Phone: 0300 123 6780
Email: developeras@lancashire.gov.uk
Your ref: 3/2025/0869
Our ref: 3/2025/0869/HDC/KW
Date: 04 November 2025

Location: Land opposite Ashbrook Ribblesdale Avenue Clitheroe BB7 2HZ
Proposal: Proposed residential development of a detached dwelling.
Grid Ref: 374199 442501

Summary

No objection subject to conditions

project	project number	drawing number
ribblesdale avenue	25.42	PL.03
name	proposed site and roof plan	
scale	date	status
1 to 100 @ A1	october 2025	planning
revision	A

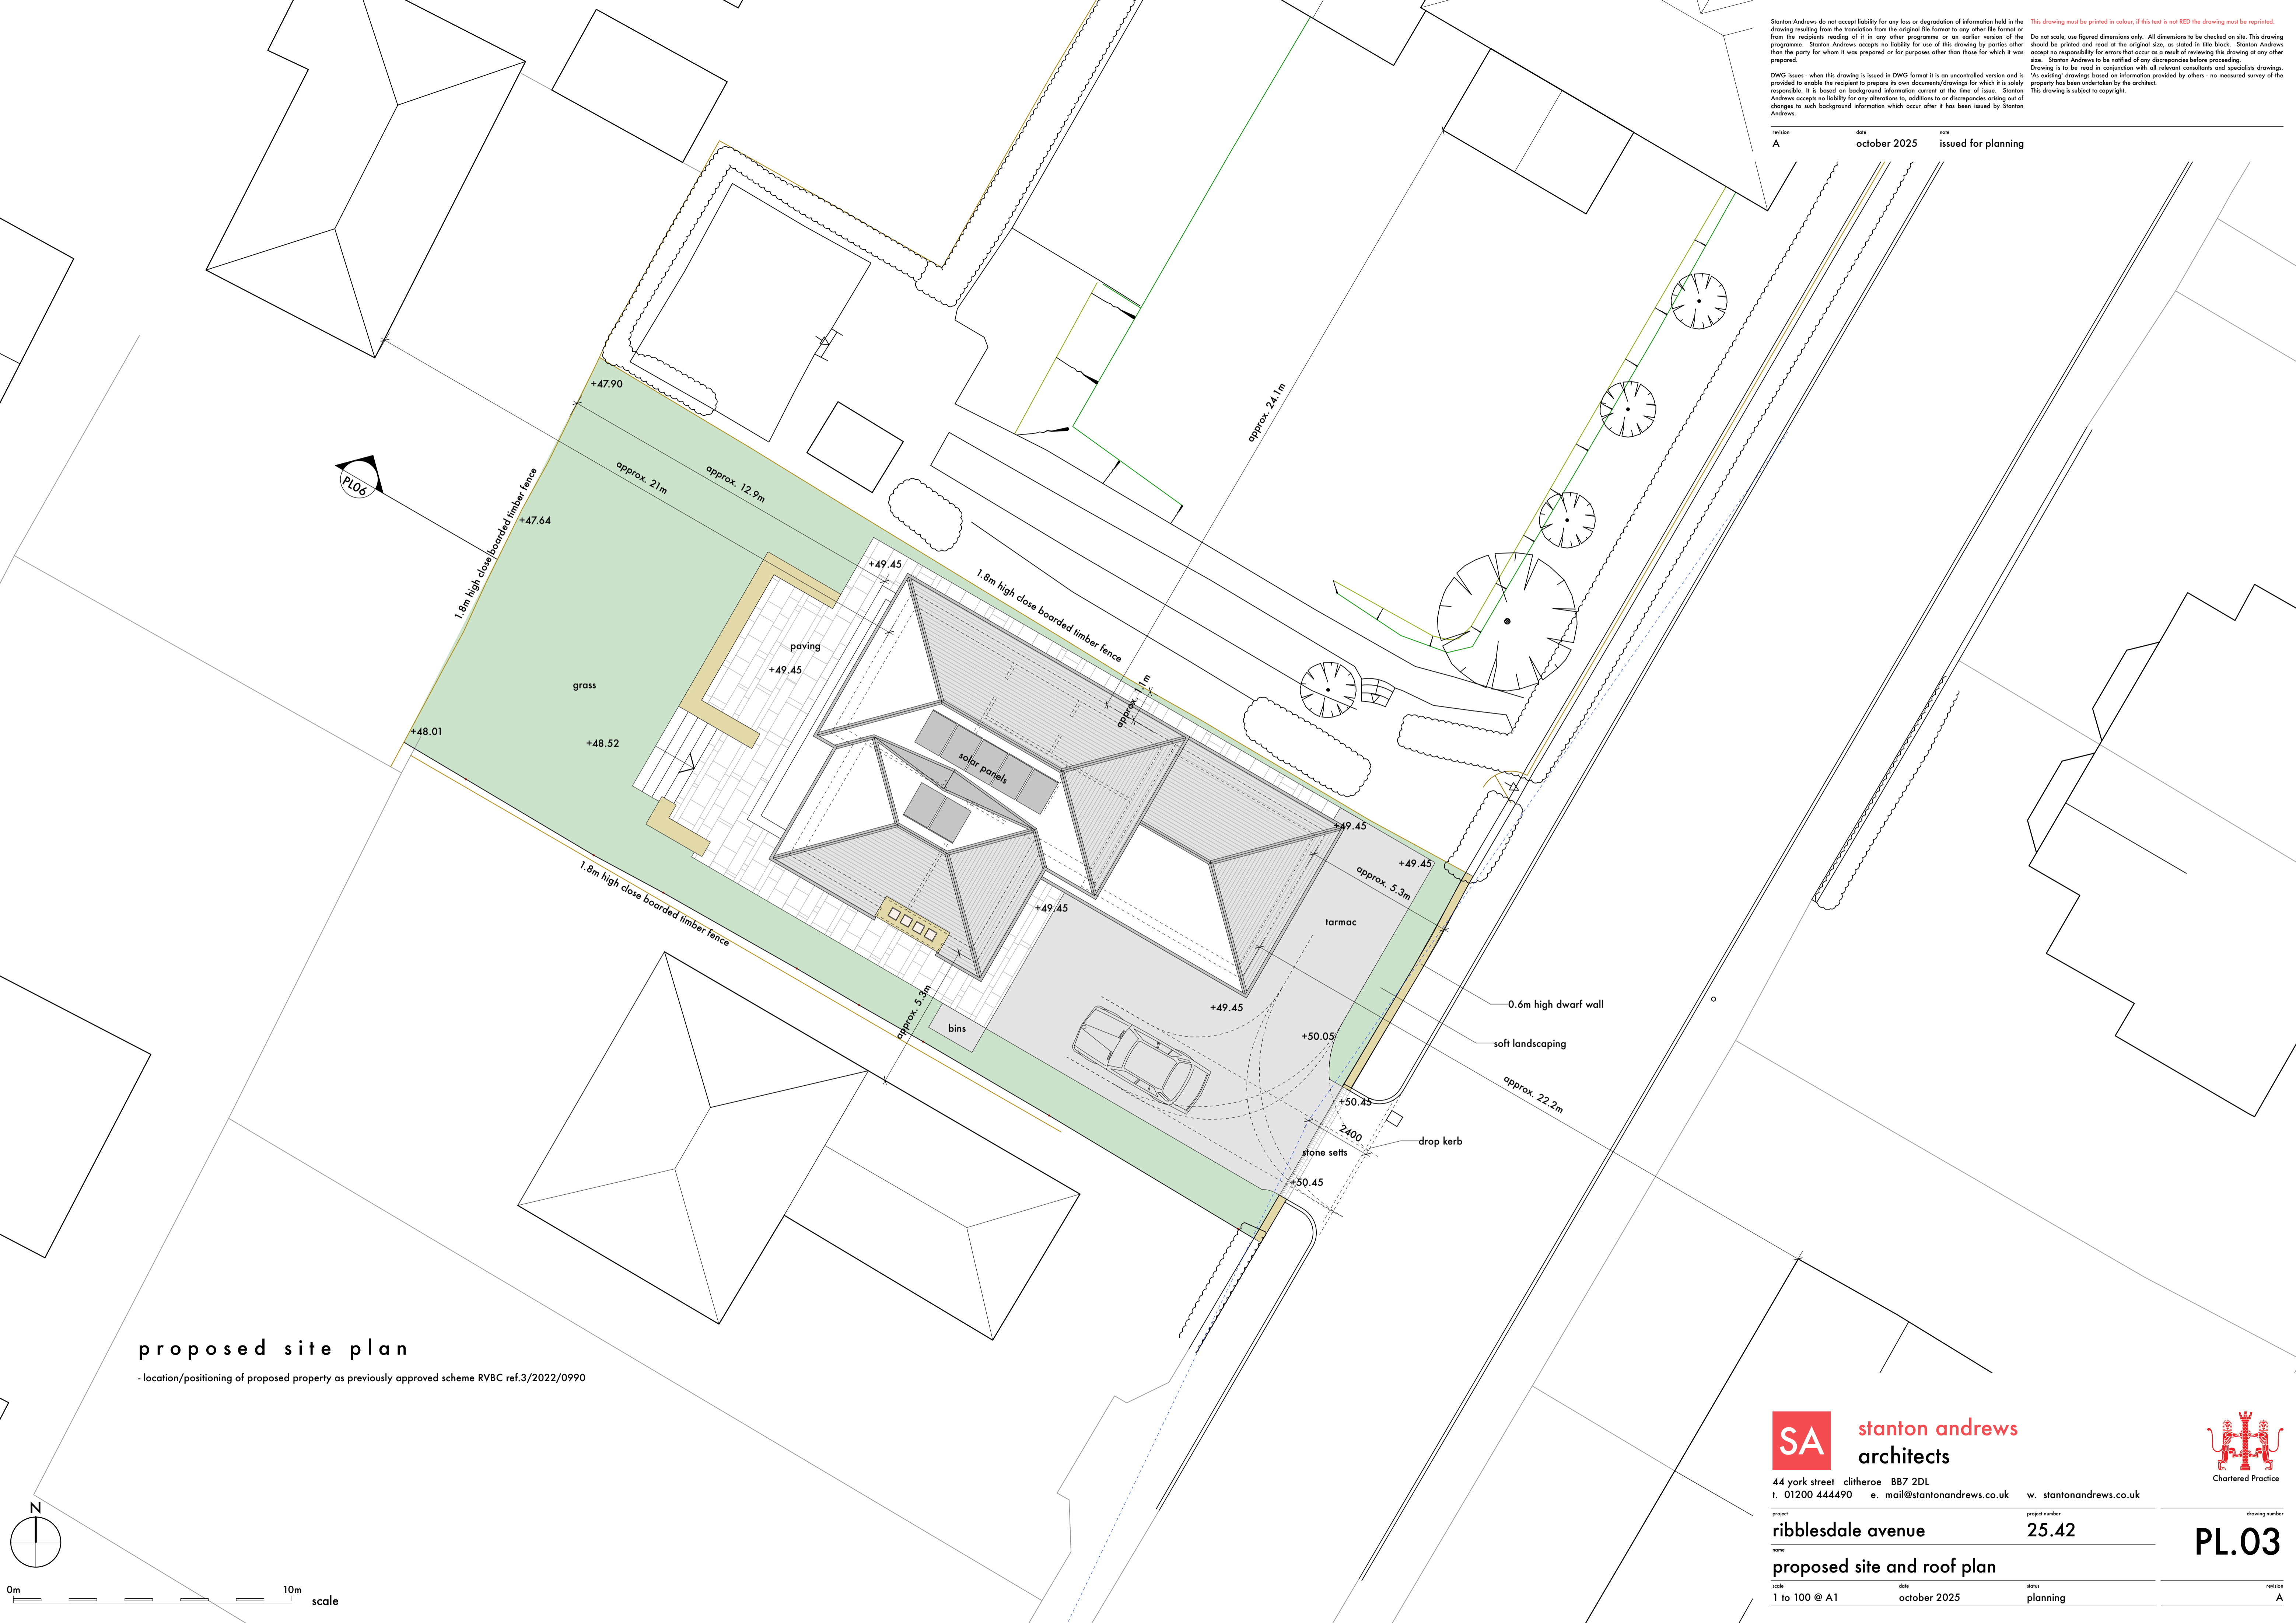
The LHA have reviewed drawing number PL.03 Rev A titled Proposed Site and Roof Plan and are aware that the proposed access is similar to the previously approved scheme under planning application 3/2022/0990. The site will be accessed from a new access onto Ribblesdale Avenue, which is an unclassified road, subject to a 20mph speed limit. The width of the proposed access complies with the LHAs guidance and to ensure adequate intervisibility between highway users at a new access a visibility splay set 2.4 metres back from the near edge of the carriageway and extending 25 metres along the nearside carriageway edge in both directions should be provided. (The site line requirement is based on table 7.1 from Manual for Streets).

The applicant has provided a visibility splay drawn within the site plan which shows that acceptable visibility can be achieved in the North/East direction. The visibility splay drawn in the opposite direction, South/West, is approximately 20m long, however given the straight nature of Ribblesdale Avenue it is likely that the additional 5m can be achieved.

The new site access will require the applicant to enter into a Section 278 agreement to create the access due to the presence of a gully located adjacent to the access, which may need to be relocated.

The LHA has reviewed drawing number PL.03 Rev A titled Proposed Site and Roof Plan and are aware that the dwelling complies with the LHAs parking standards as defined in the Joint Lancashire Structure Plan, as 2 off-street parking spaces can be catered for within the proposed driveway.

4. No part of the development hereby permitted shall be occupied until such time as the access arrangements shown on drawing number PL.03 Rev A have been implemented in full.

5. No part of the development hereby permitted shall be occupied until such time as vehicular visibility splays of 2 metres by 25 metres have been provided at the site access. These shall thereafter be permanently maintained with nothing within those splays higher than 1 metres above the level of the adjacent footway/verge/highway.

6. The development hereby permitted shall not be occupied until such time as the parking and turning facilities have been implemented in accordance with drawing number PL.03 Rev A. Thereafter the onsite parking provision shall be so maintained in perpetuity.
